From: Stuart Corbey
Sent: 17 May 2019 11:57
To: Planning.Responses
Subject: FW: AL/30/19/HH Stable Cottage Norton Lane -

From: Stuart Corbey <Stuart.Corbey@arun.gov.uk>
Date: Thursday, 16 May 2019 at 14:32
To: "'rjcatkinson@btinternet.com'" [REDACTED]
Subject: AL/30/19/HH Stable Cottage Norton Lane -

Drawing Number: 2018/20/04 Rev.

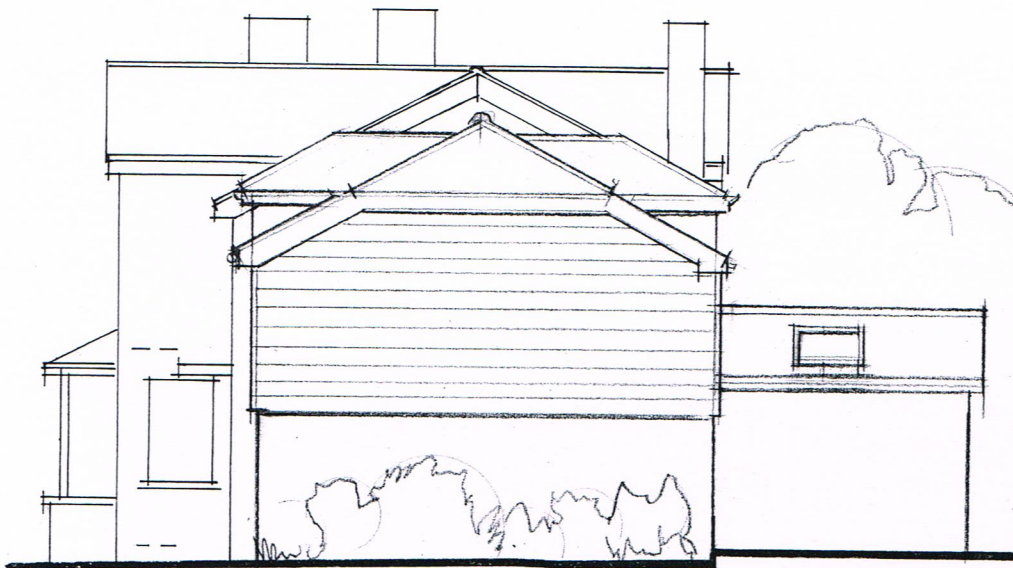
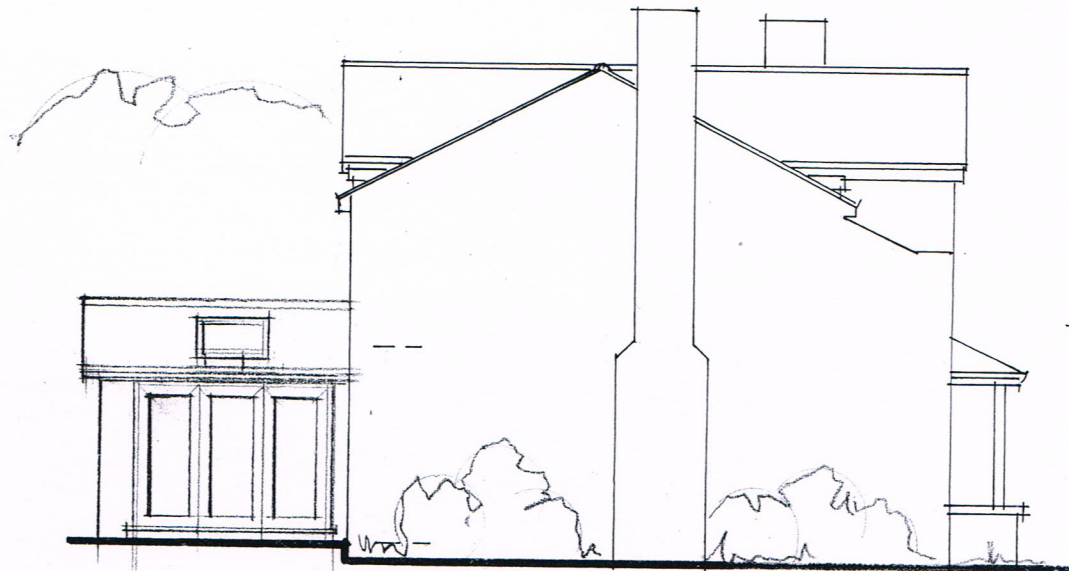
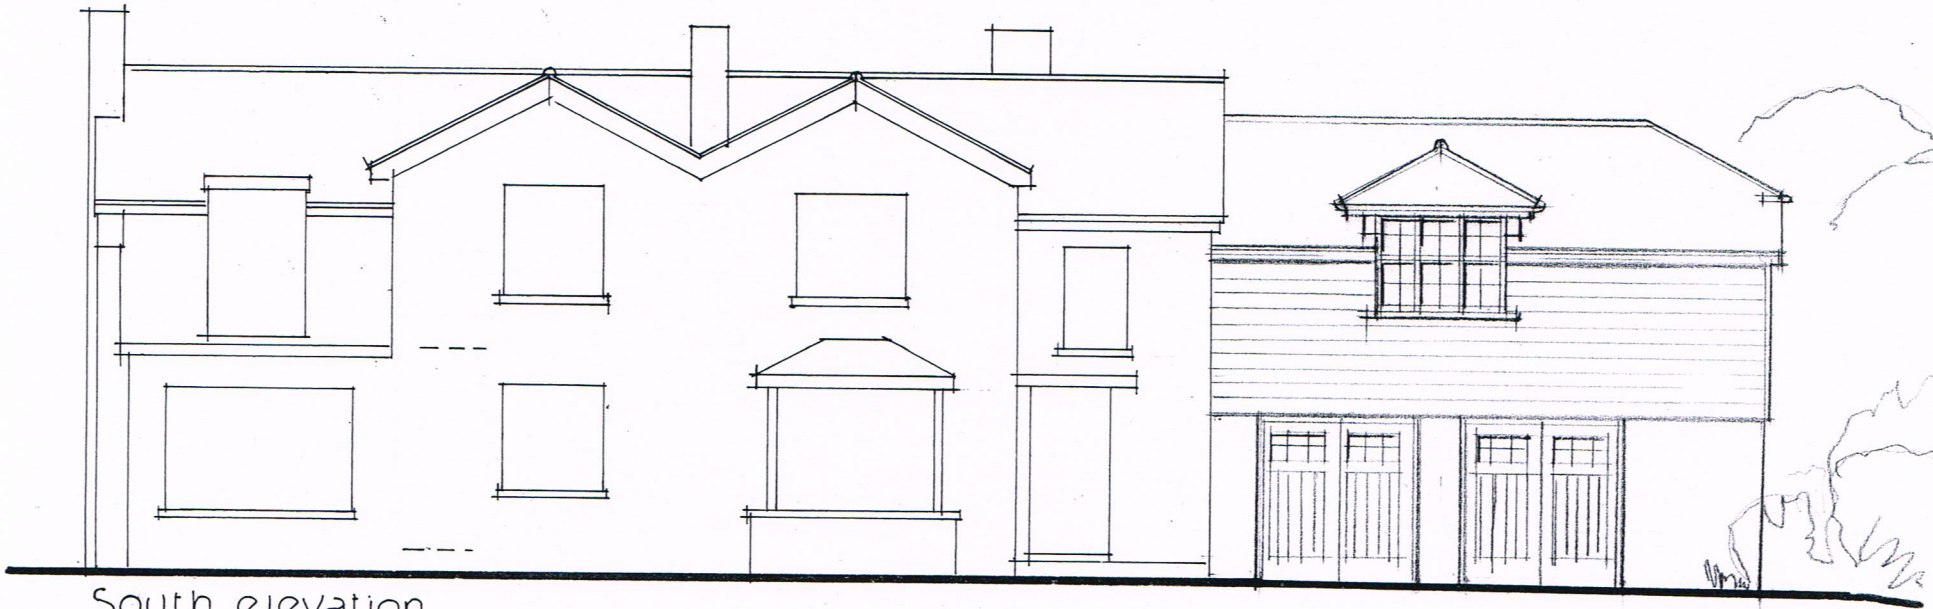
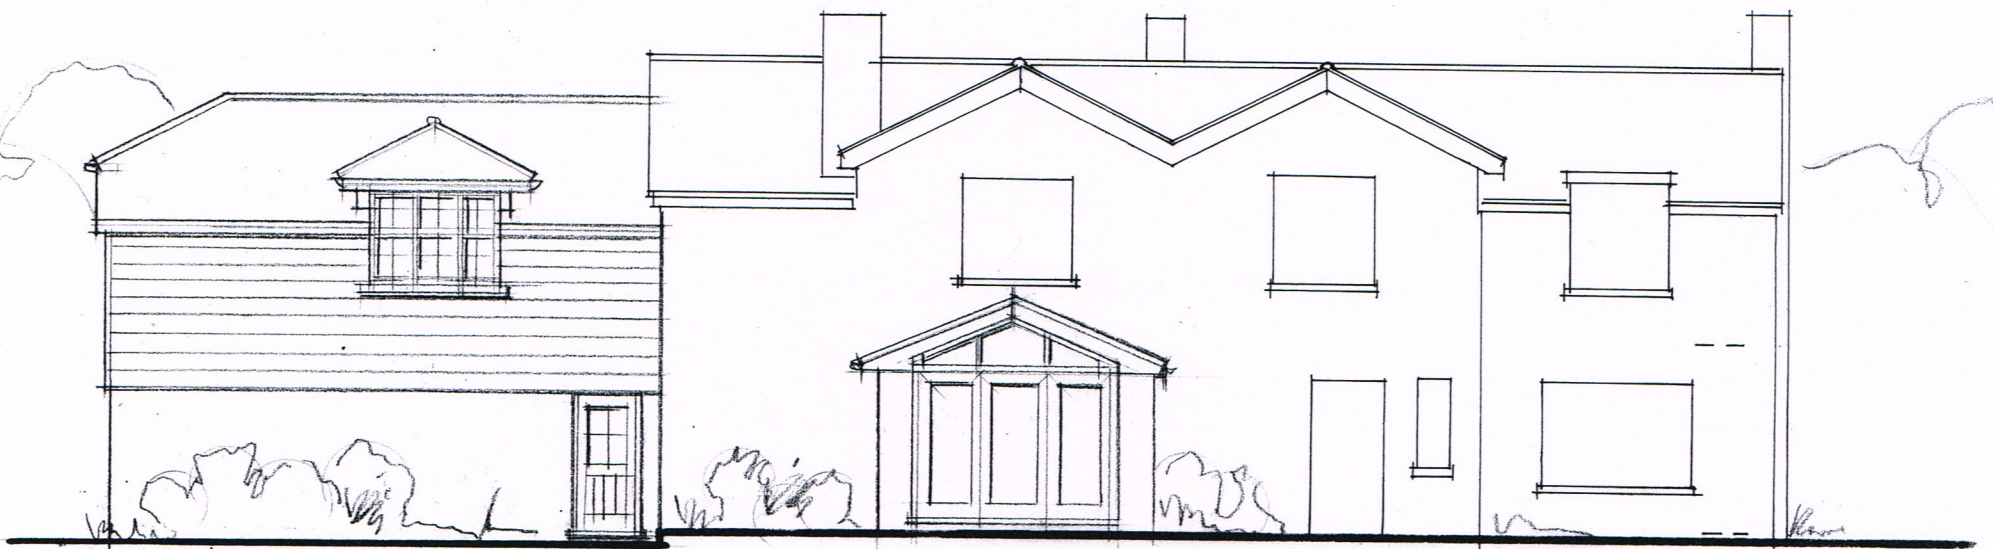
I have just had word from our conservation team that the design would need to be tweaked in order for it to respond more sympathetically to the conservation area and appearance of the existing dwelling. To alter the barn hip to a gable would be preferred. We consider this would make for an acceptable scheme and support the Policies on design within the Arun Local Plan and Neighbourhood Policy requirements respectively.

1. Please substitute the attached revised drawings 4A & 5A showing the design amended with the gable end.
2. Agreement to the extension of time to 31/05/2019.
